**Town & Country Planning Act 1990 (as amended)
Town and Country Planning (Development Management Procedure) (England) Order 2015
Application for Planning Permission**

Development Proposed single four bed dwelling.

Location The New Stables Kiington

Client	Description
	BLOCK PLAN

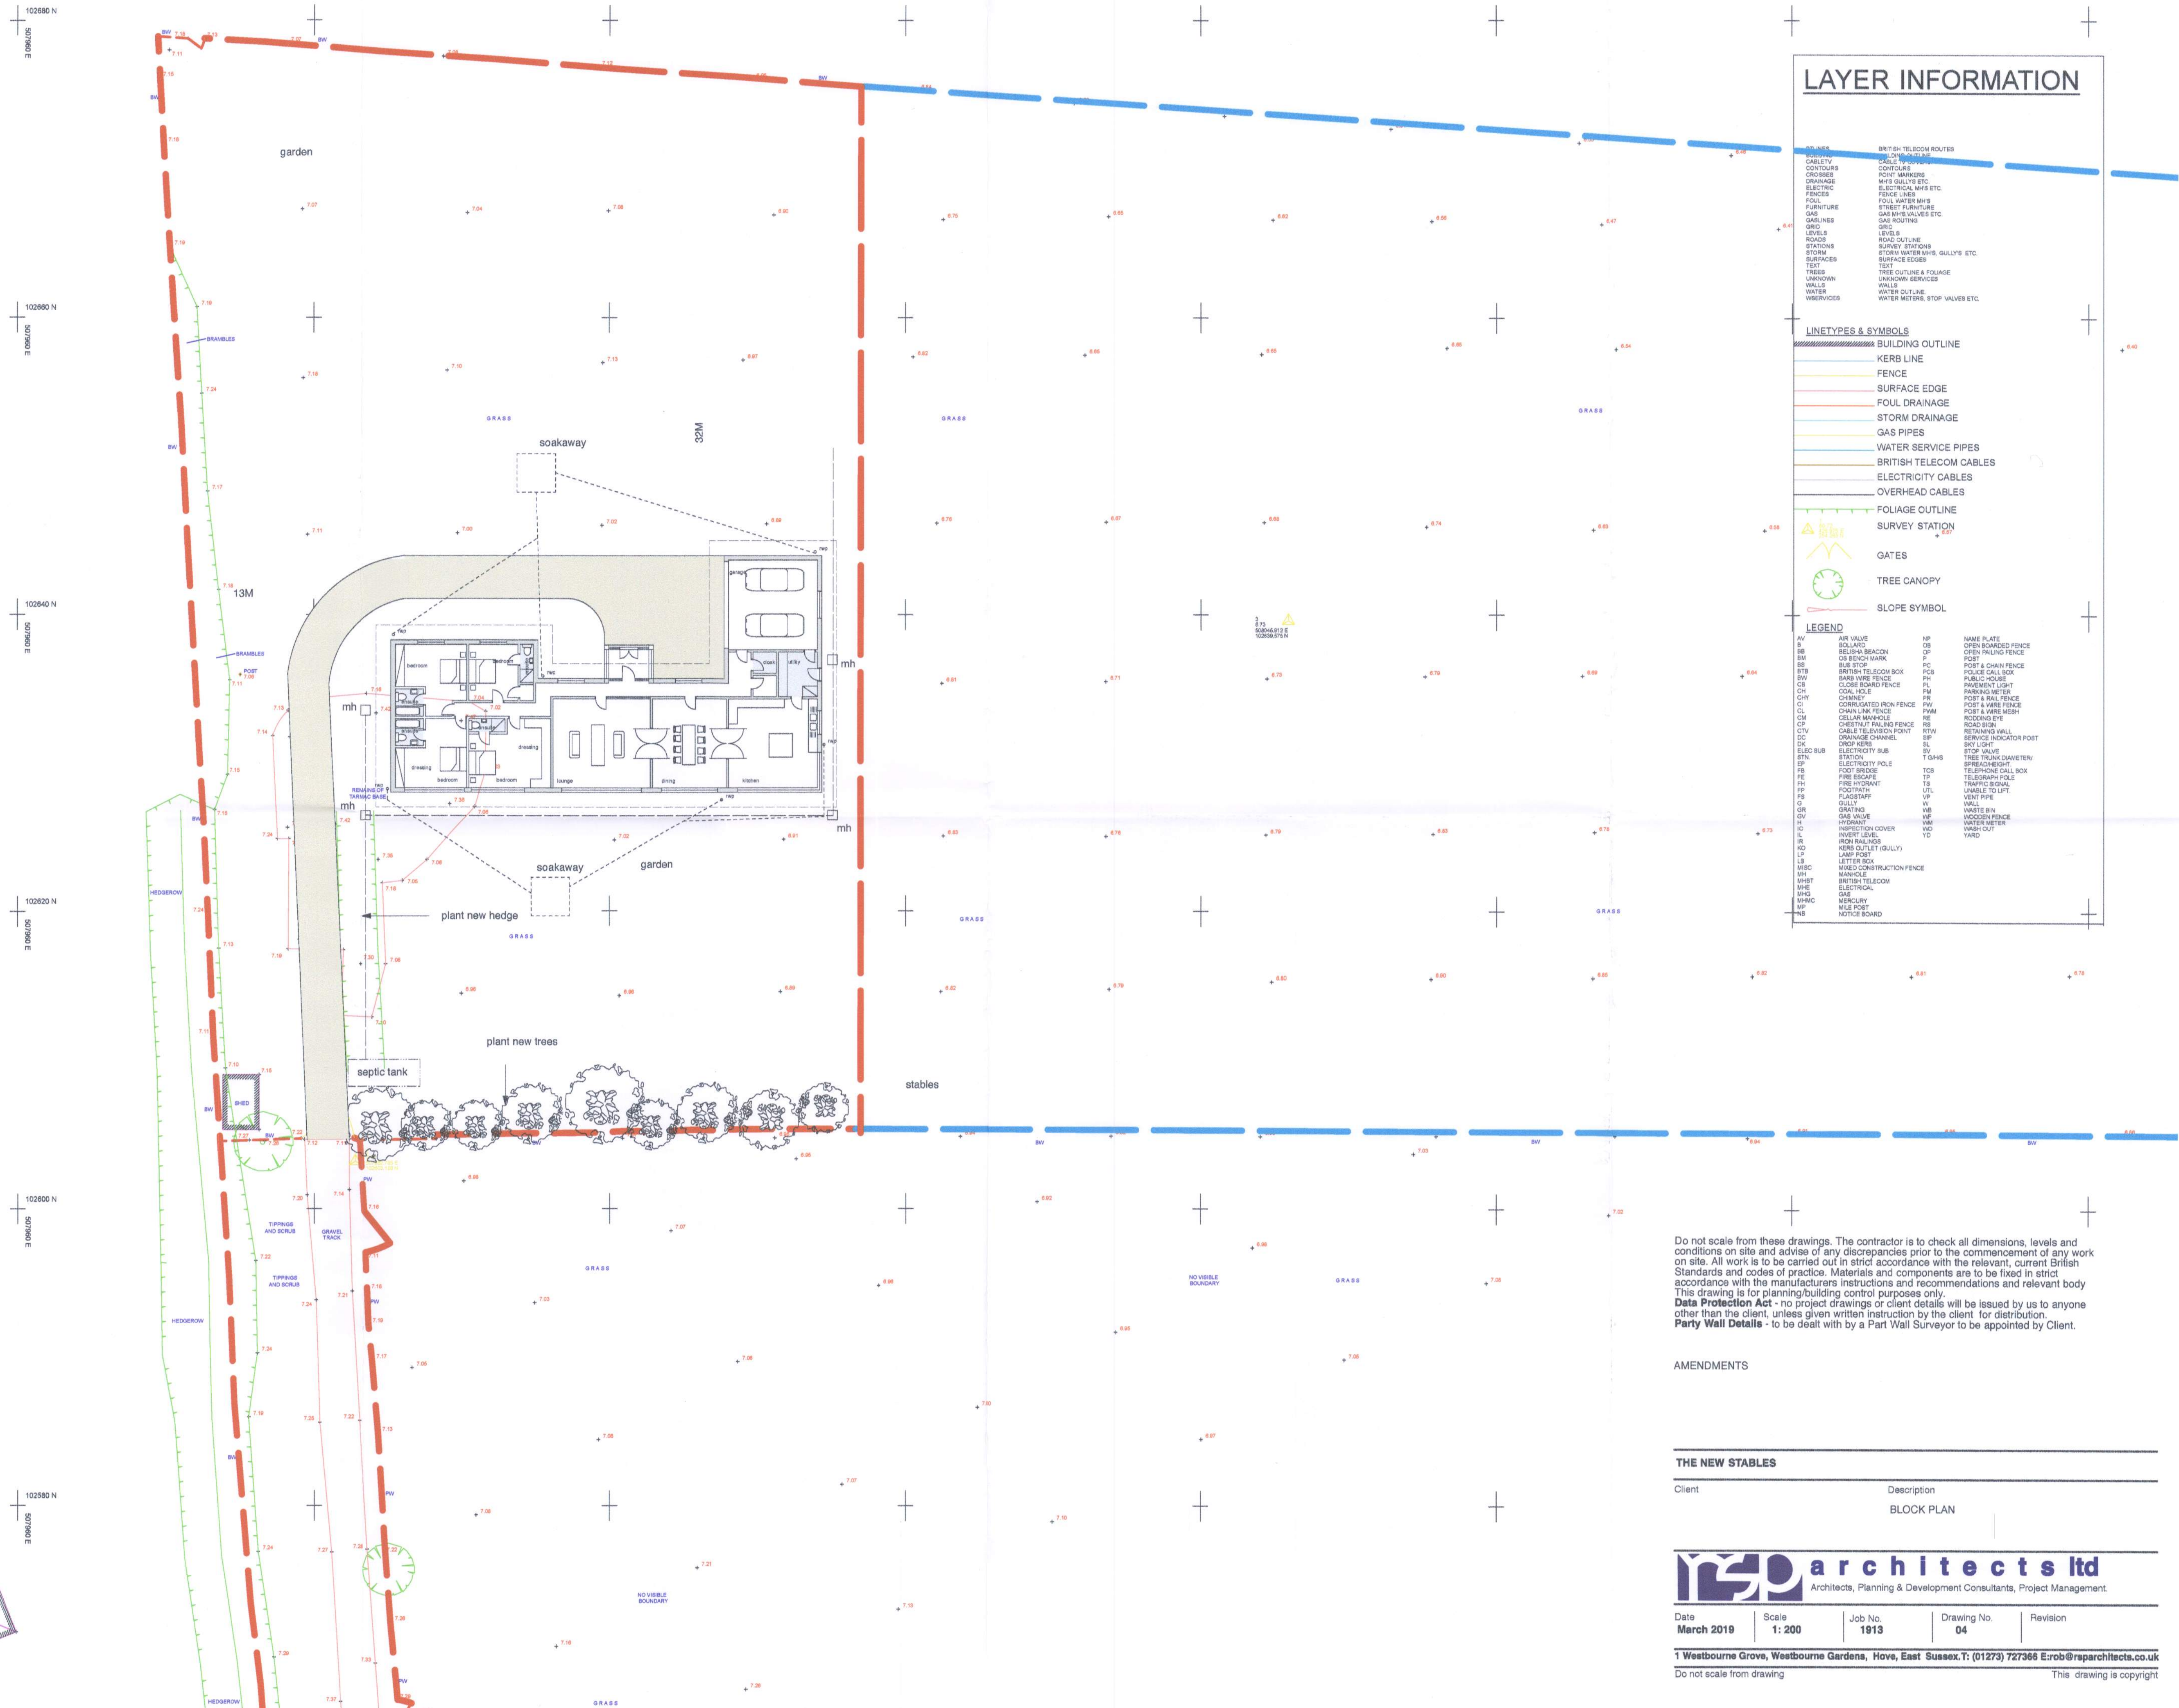
Block Plan

You are required to submit dimensions from the proposed dwelling to all site boundaries on the proposed block plan.
